CITY OF ALBUQUERQUE

RE: Advanced Auto Parts
San Mateo/Claremont
Grading and Drainage Plan
Engineers Stamp Date 8/7/15 (H17D111)

RE: H17-D111 – Advance Auto Parts, San Mateo and Claremont: Drainage and Hydrology Review Comments Response

RETENTION POND & OUTFALL DETAIL
SCALE 1" = 10'

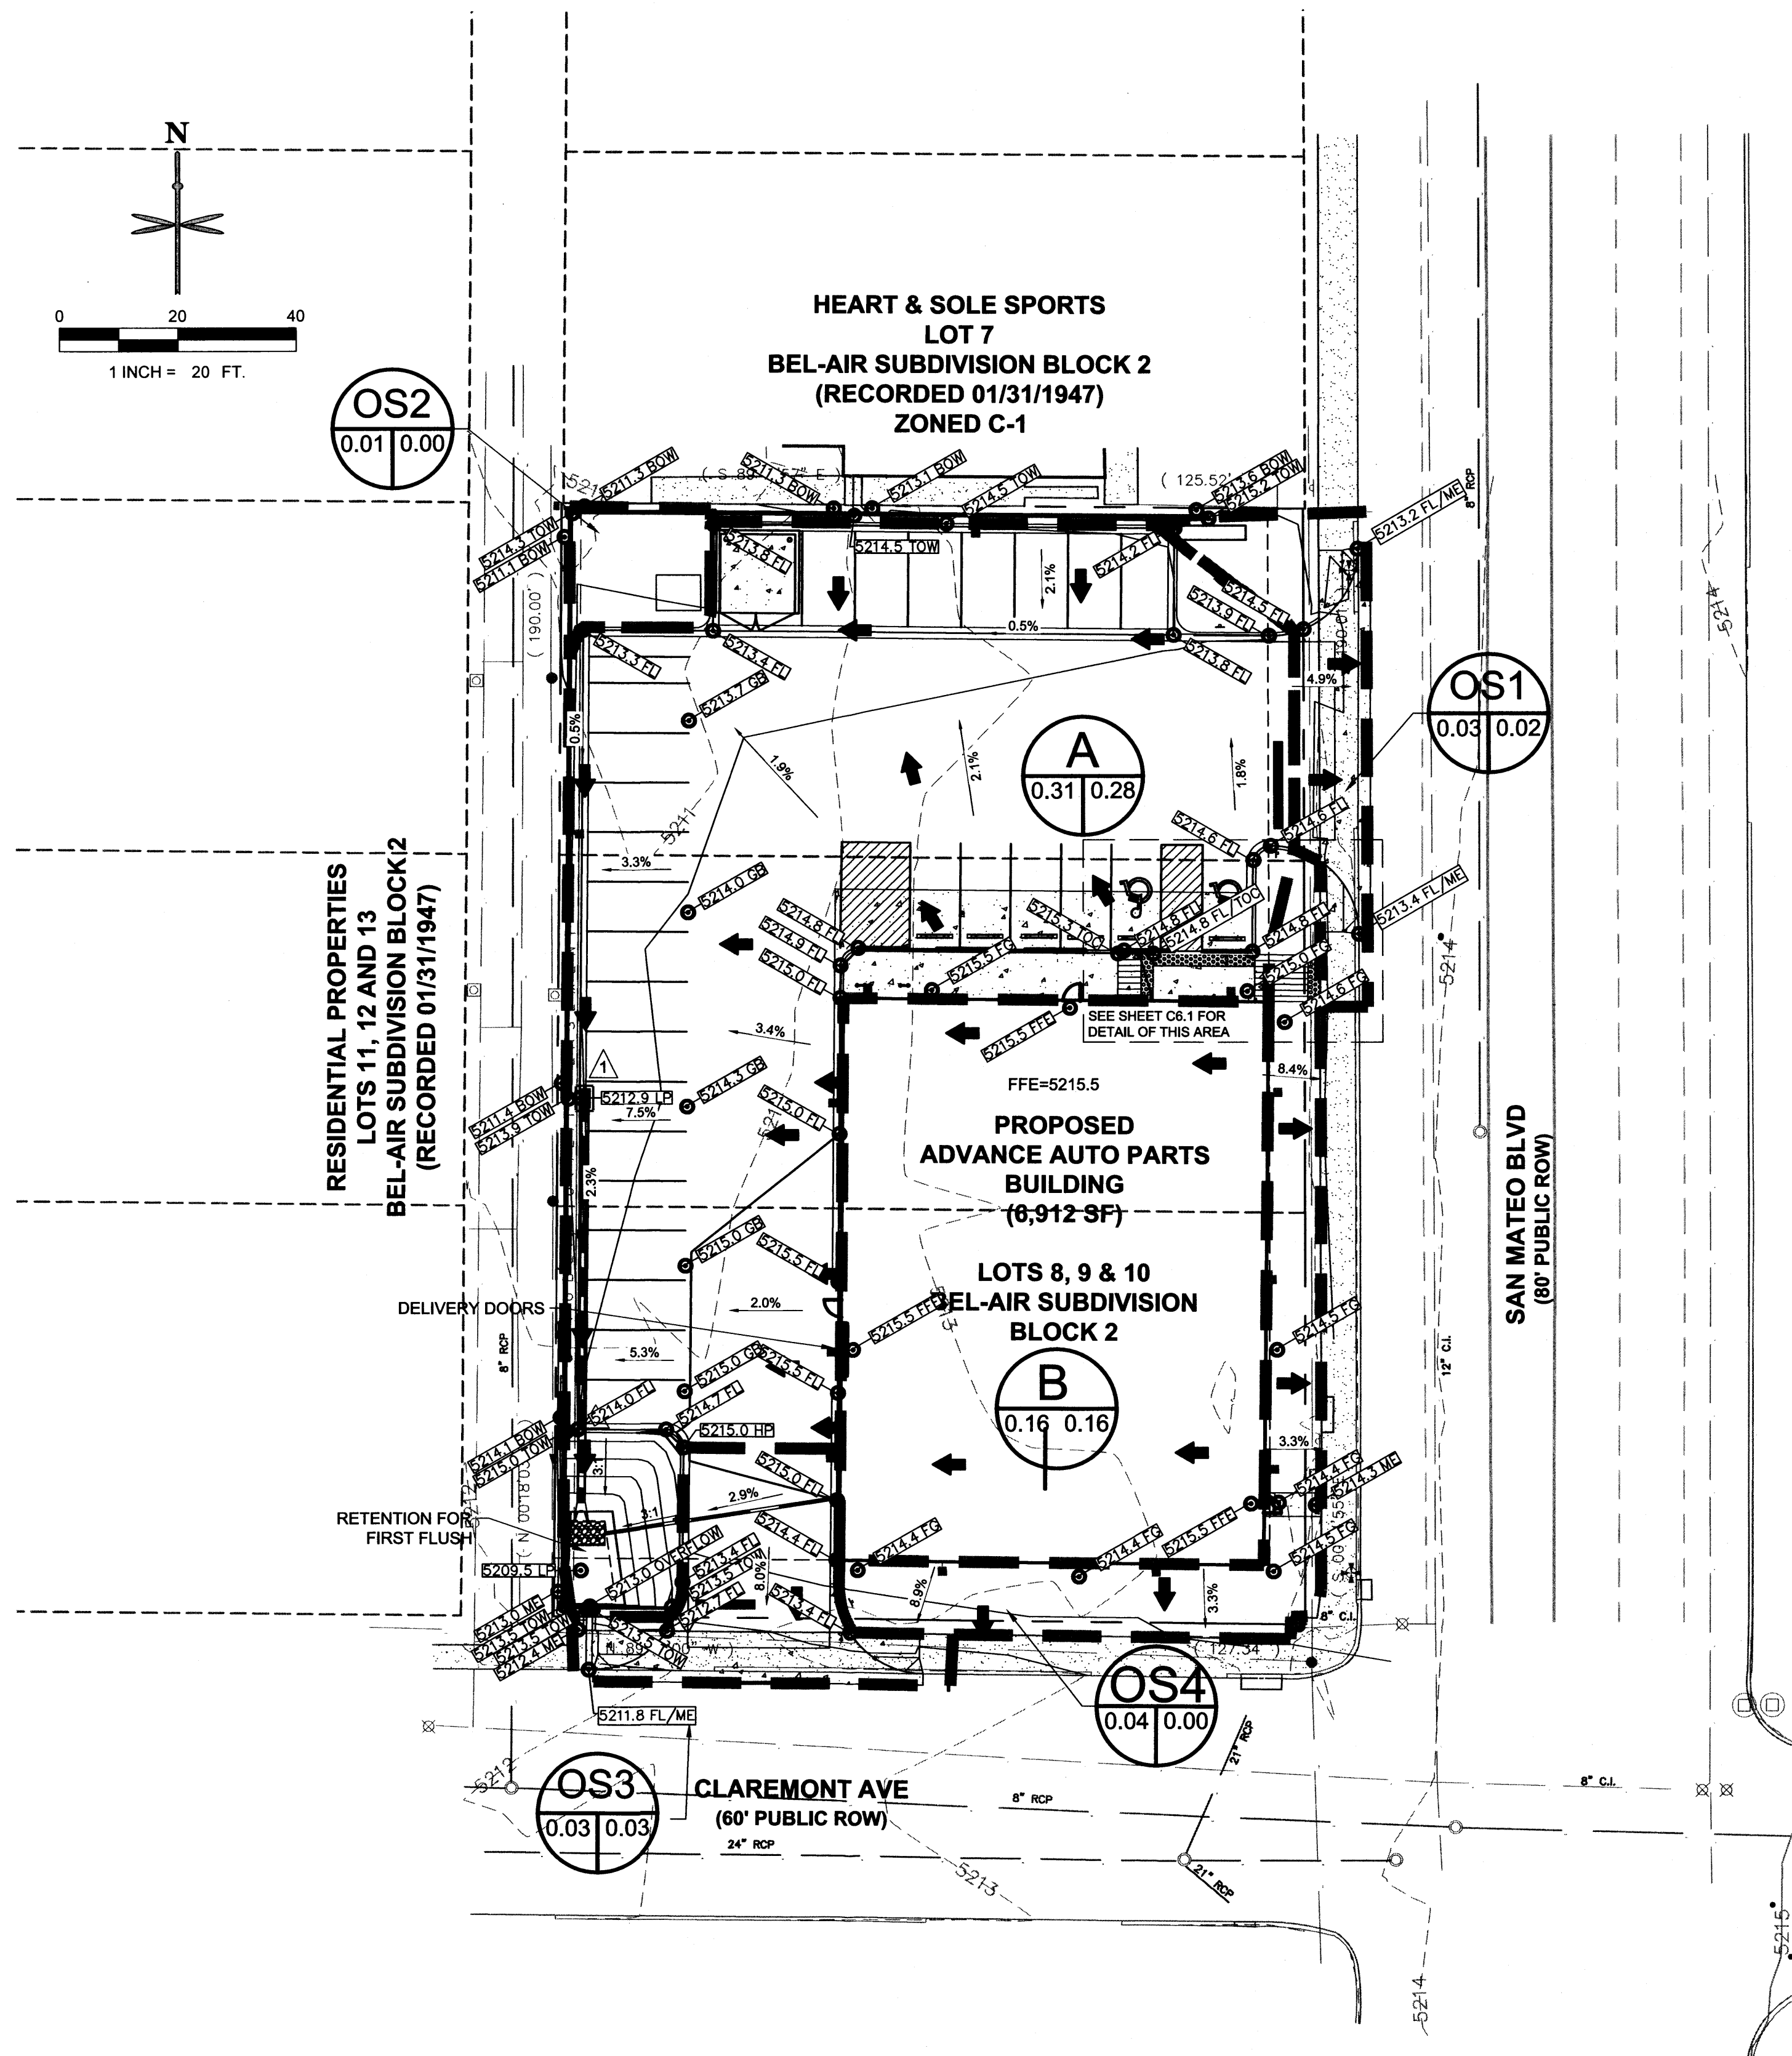
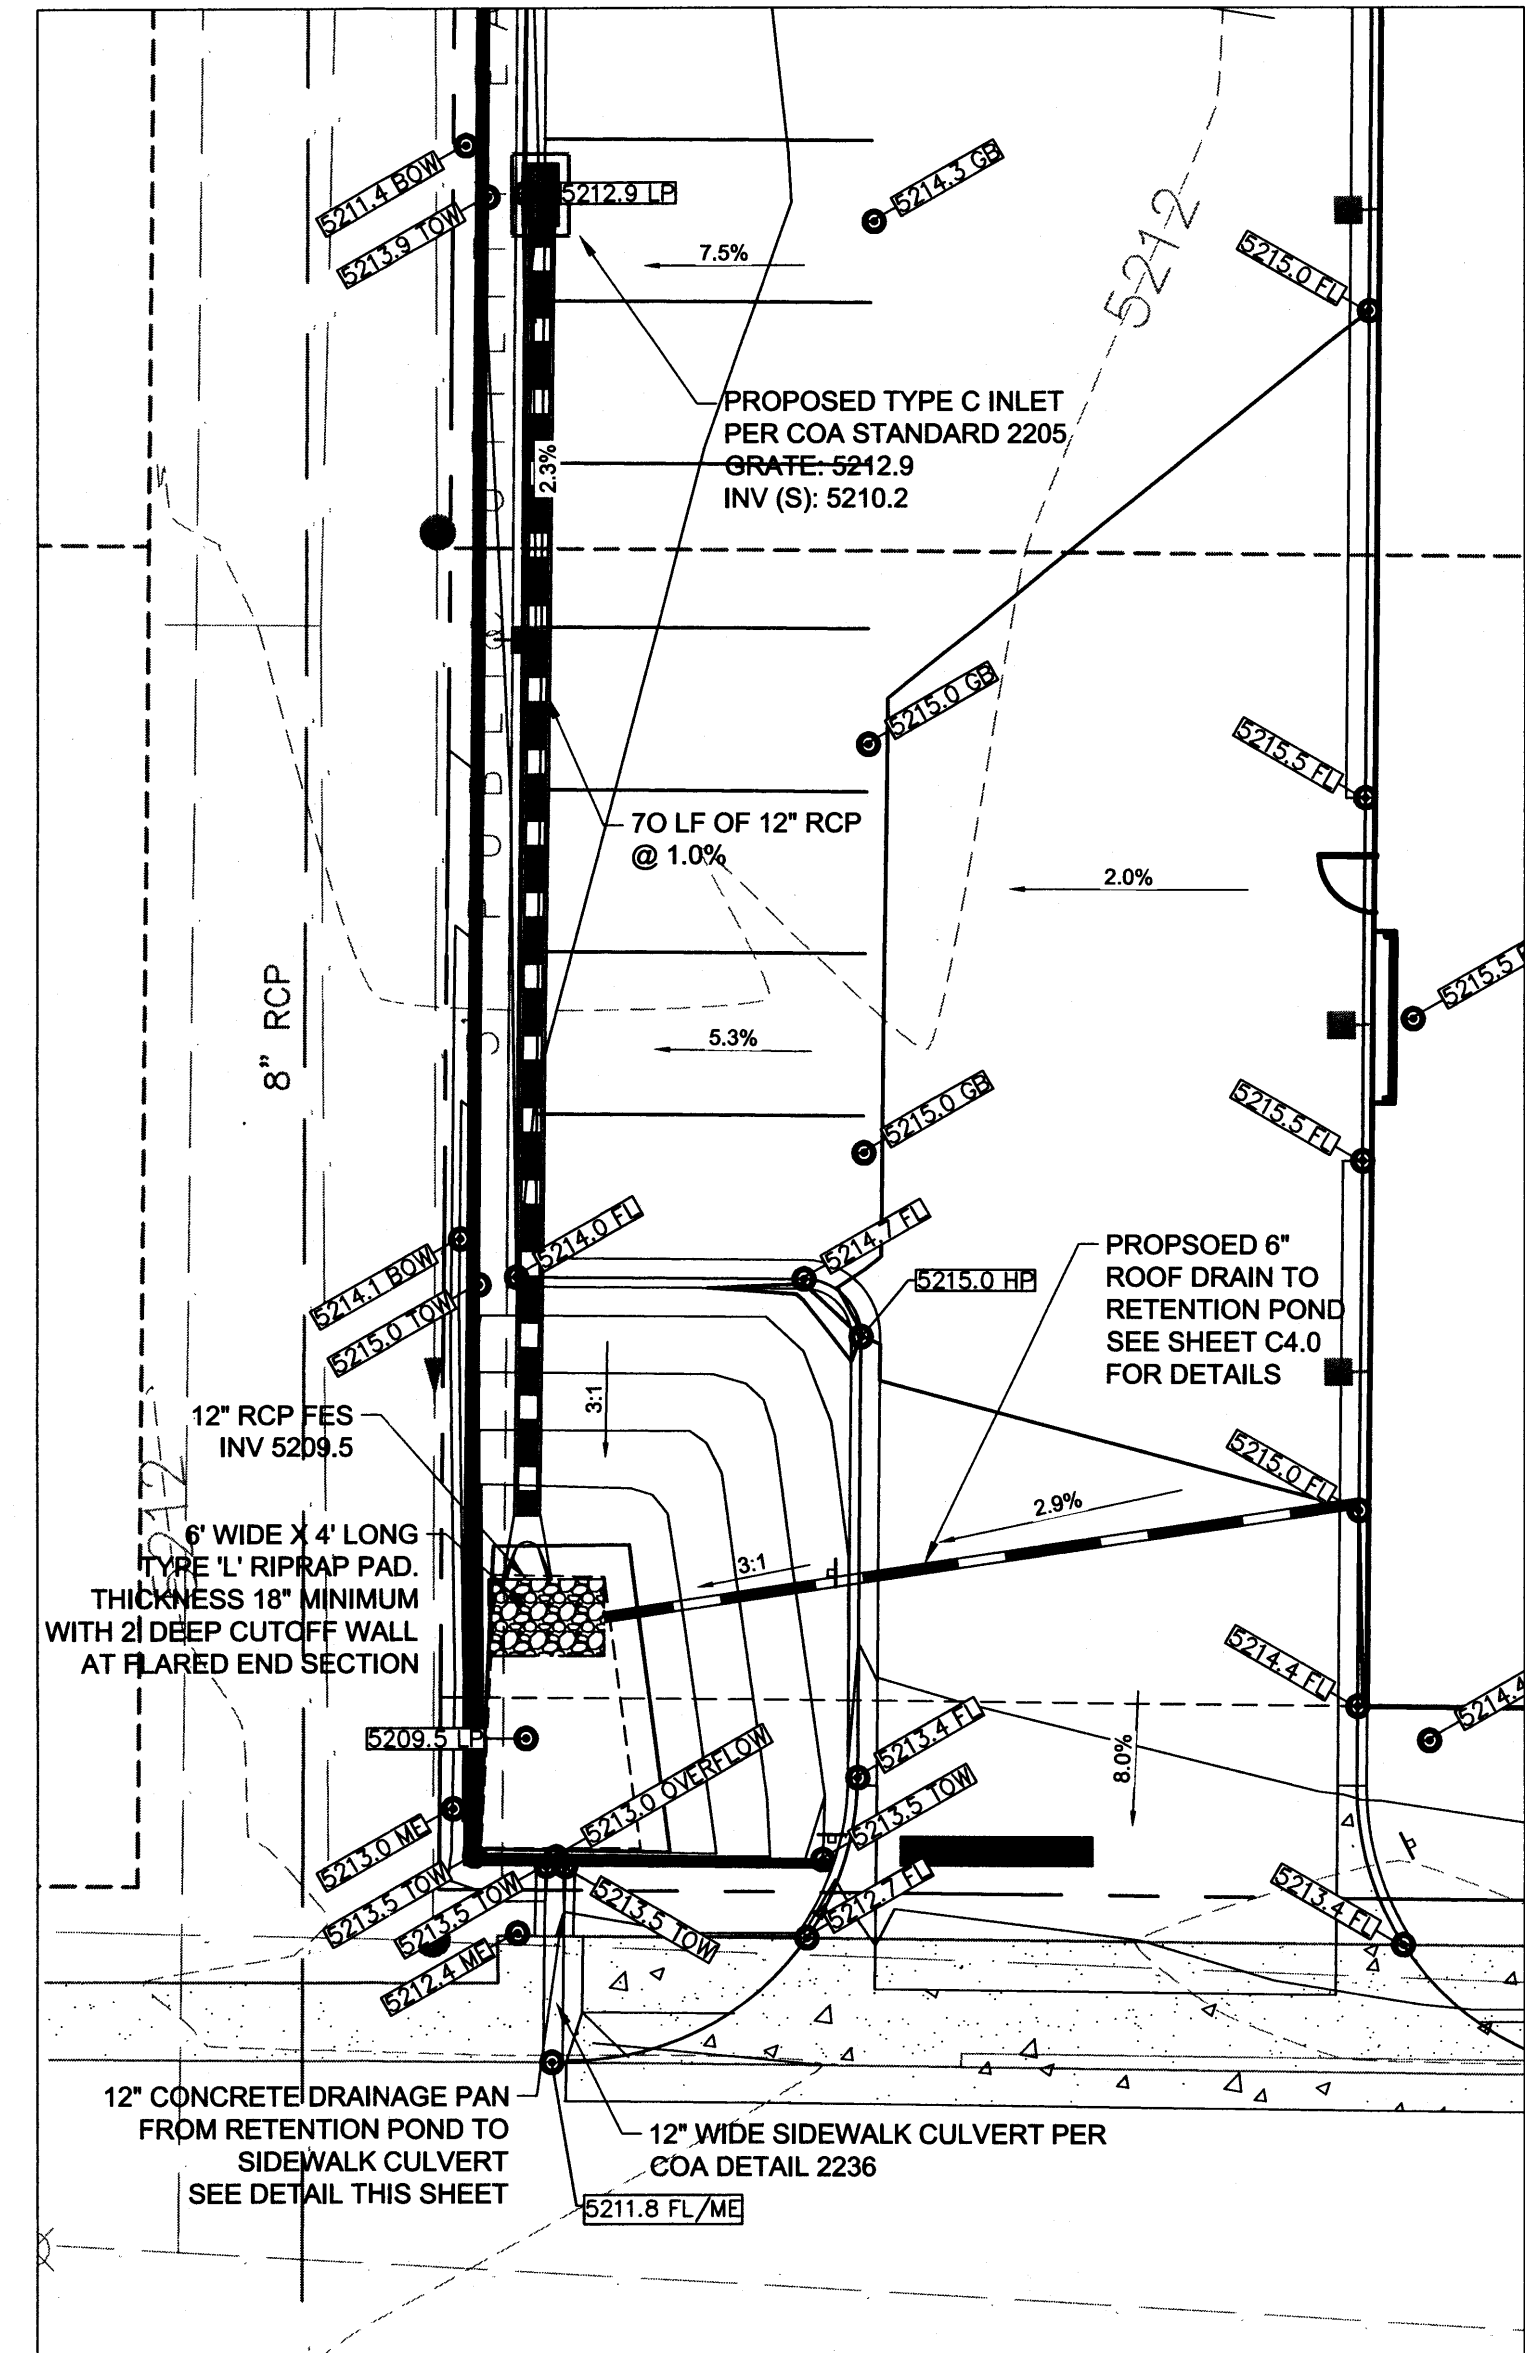
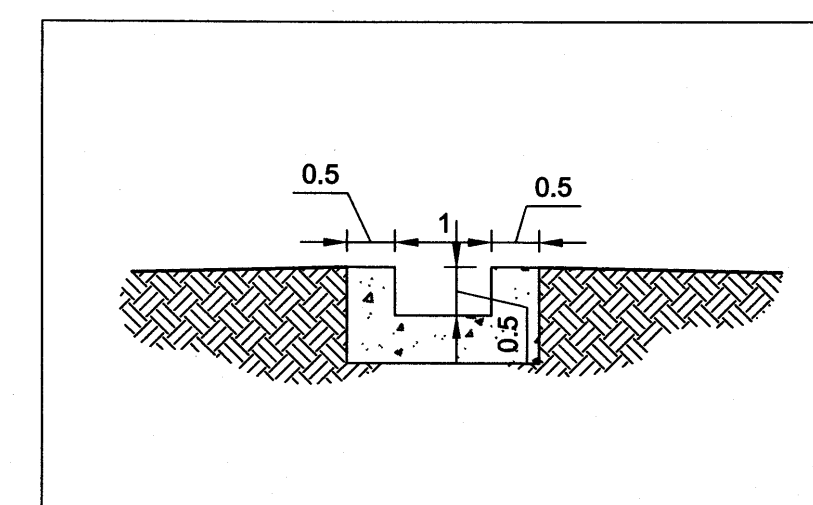
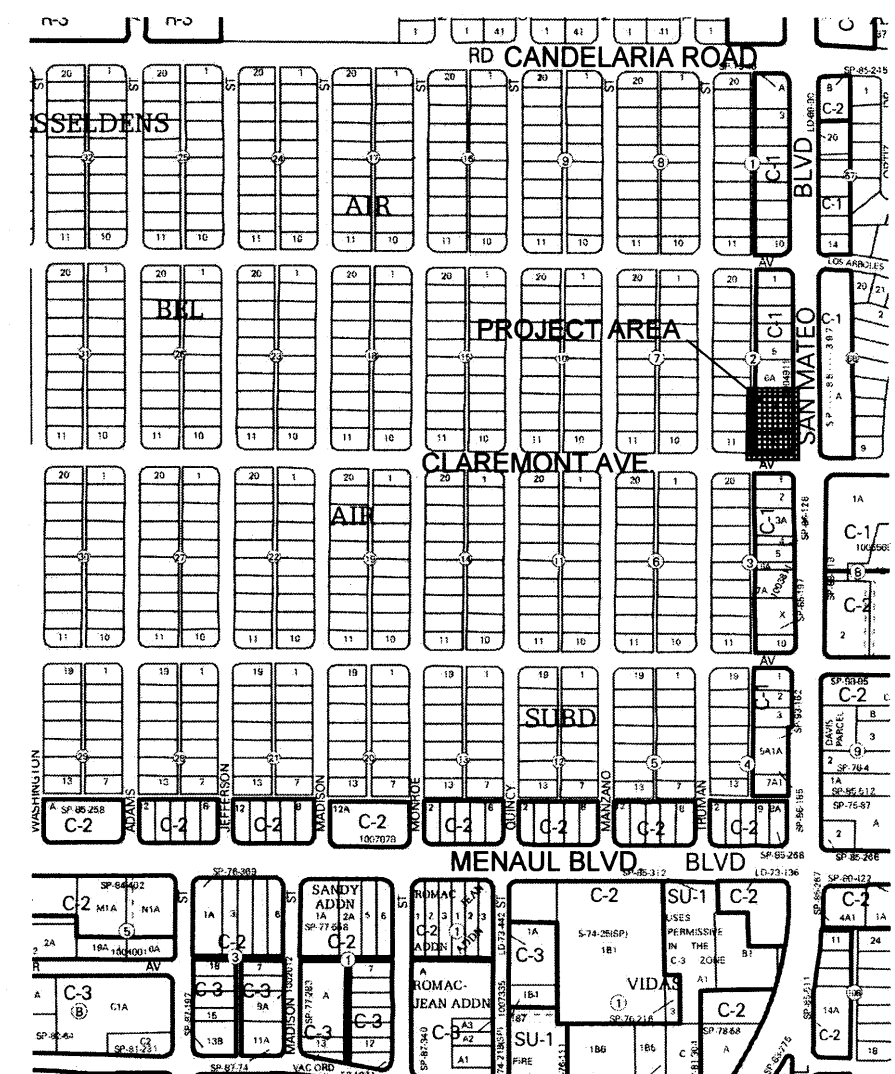
2. Provide an invert for the pipe in the pond.

6. A 2ft curb cut is needed on the north side of the pond.

- 7. An emergency overflow is needed for the pond. Direct the emergency overflow for the pond toward the drive pad in Claremont.
- 8. RESPONSE: As part of the drainage re-design a formalized outfall structure to Claremont has been added. This includes a concrete channel and sidewalk culvert. This has been sized to accommodate the 100-year flood event.
- 9. Provide a Floodplain Permit for this site. Also, before CO is given for this site a LOMR-F must be completed and an elevation certificate provided.

RESPONSE: As part of the drainage re-design the existing outfall pipe has been removed. The new design has a pipe that discharges into the pond and overflow outfall structure. Invert elevations have been included for the new pipe and outfall structure.

RESPONSE: As part of the drainage re-design the curb cut to the pond is no longer required. Drainage to the pond is conveyed via and inlet and pipe.
